ASDA FERRING PFS APPLICATION – HIGHWAY OFFICER RESPONSE

Client/Project	ASDA
Title of Document	Highway Officer Response (ASDA Ferring)
Date	27/02/2018
Reference number	17_72B (Ferring)
Number of pages	4
Author / Date	Nick Barron (Senior Consultant) – 27/02/2018

This file note has been prepared by SYSTRA Ltd on behalf of ASDA store Ltd, in response to Highways Officer comments relating to the planning application in support of a proposed 6-pump (12 filling position) petrol filling station (PFS) at its Ferring Store, West Sussex.

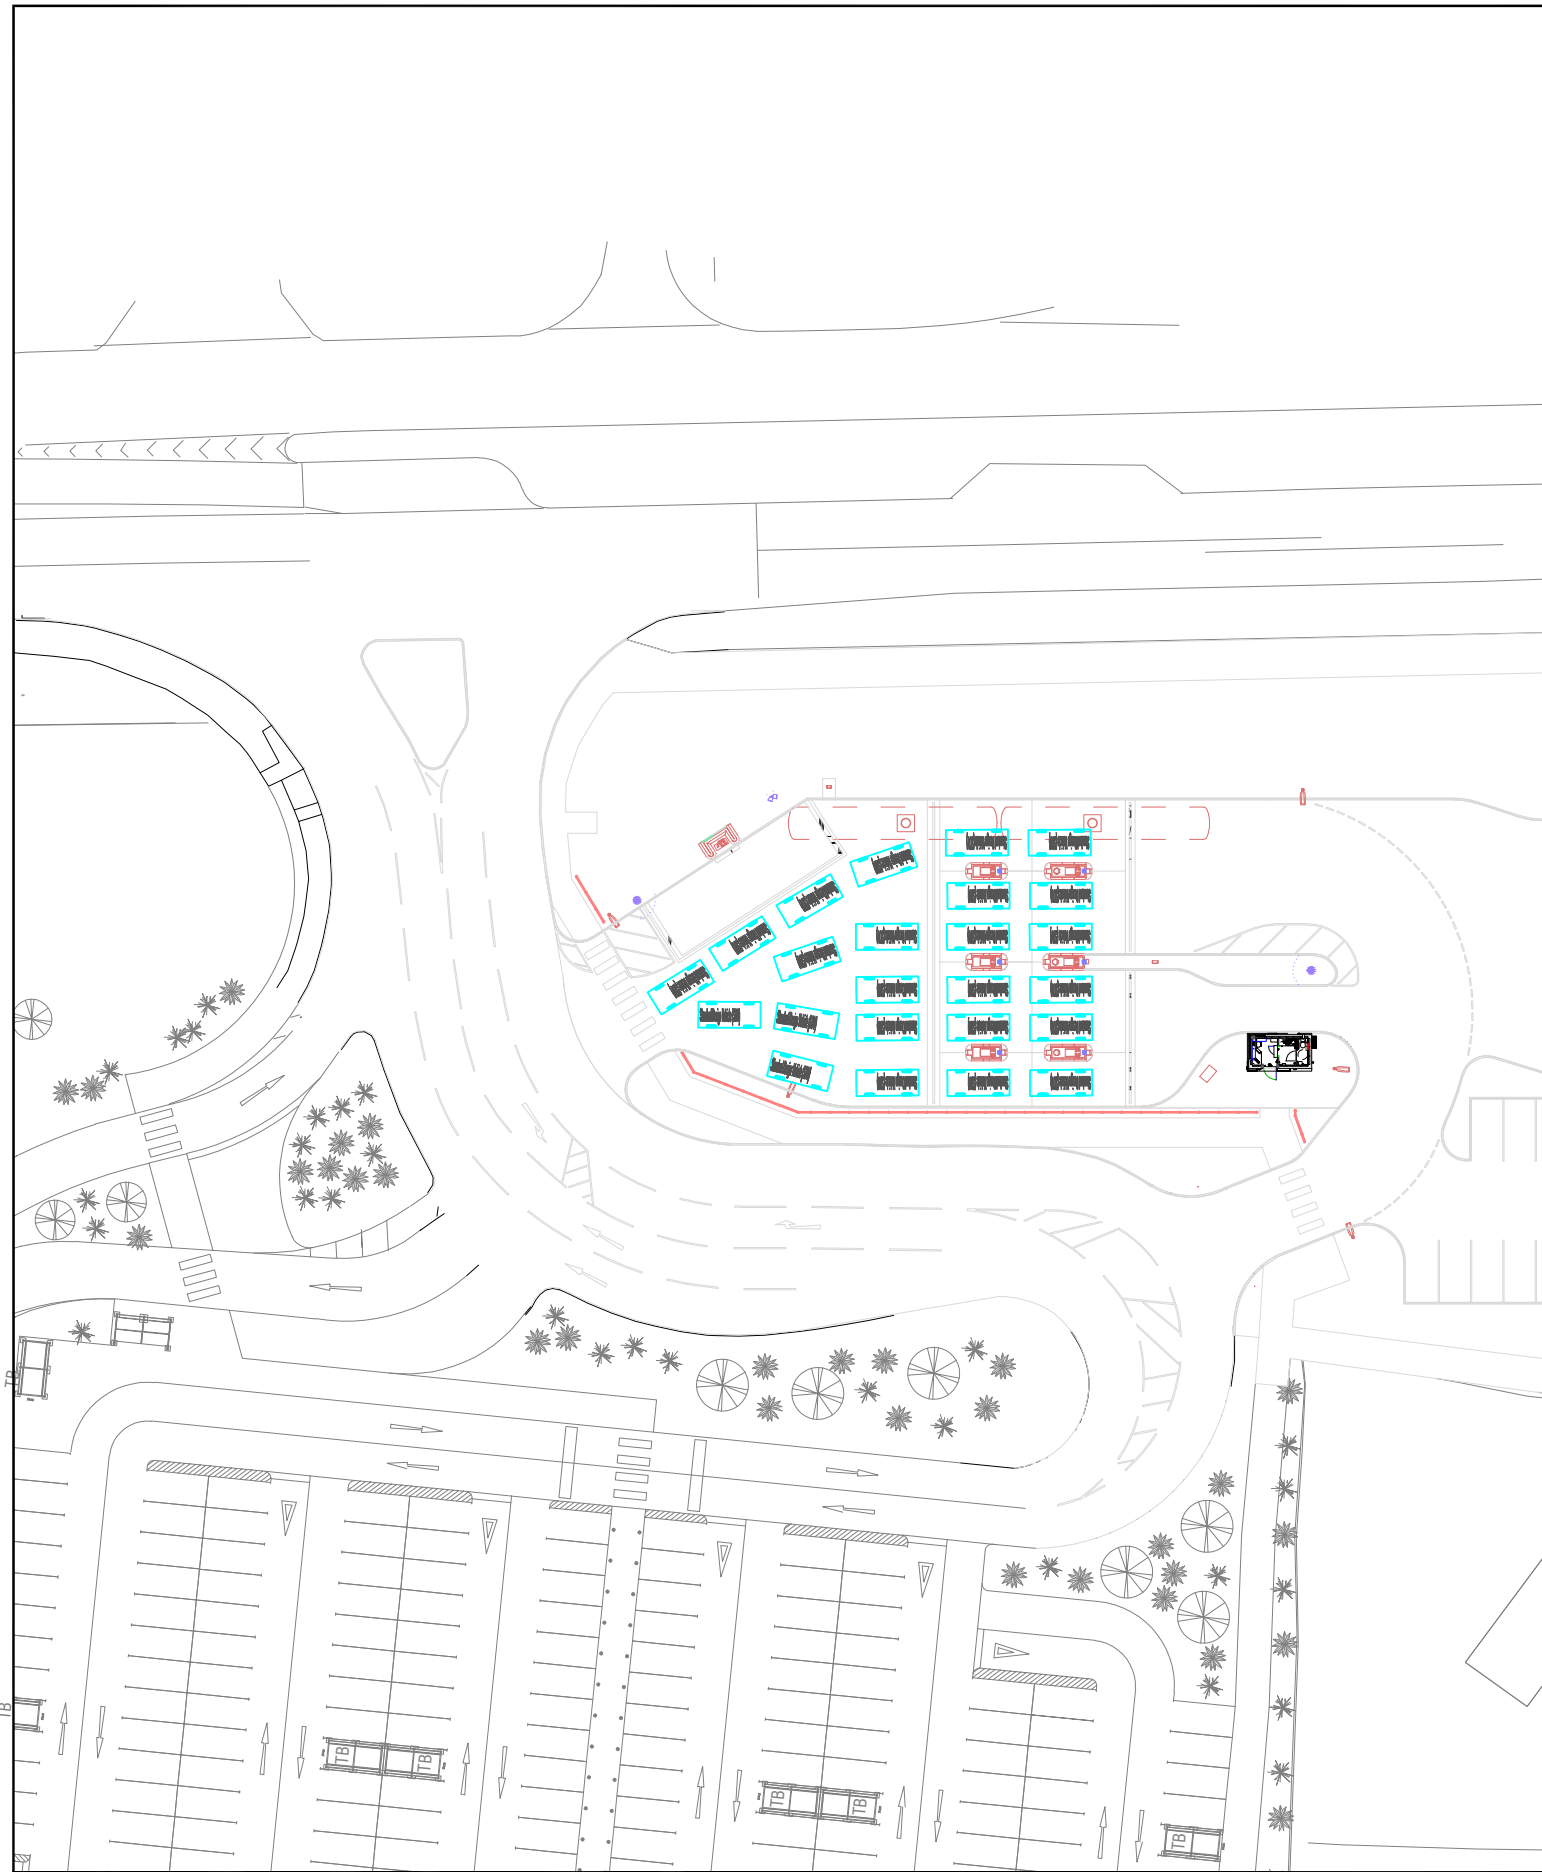
The attached figure illustrates that the spatial forecourt has the capacity to accommodate a total of 24 vehicles at any given time. This is composed of cars which are occupying a filling position (12) and cars which are waiting to move forwards to a pump (12). This equates to a total of 30% of the total PFS hourly demand shown in Table 4.2 of the submitted TS (78 vehicles).

For the avoidance of doubt, the graphic is not suggestive of instantaneous demand, rather it demonstrates that even in exceptional circumstances, the site layout has the physical capacity to accommodate a substantial number of vehicles without impacting on the adjoining public road.
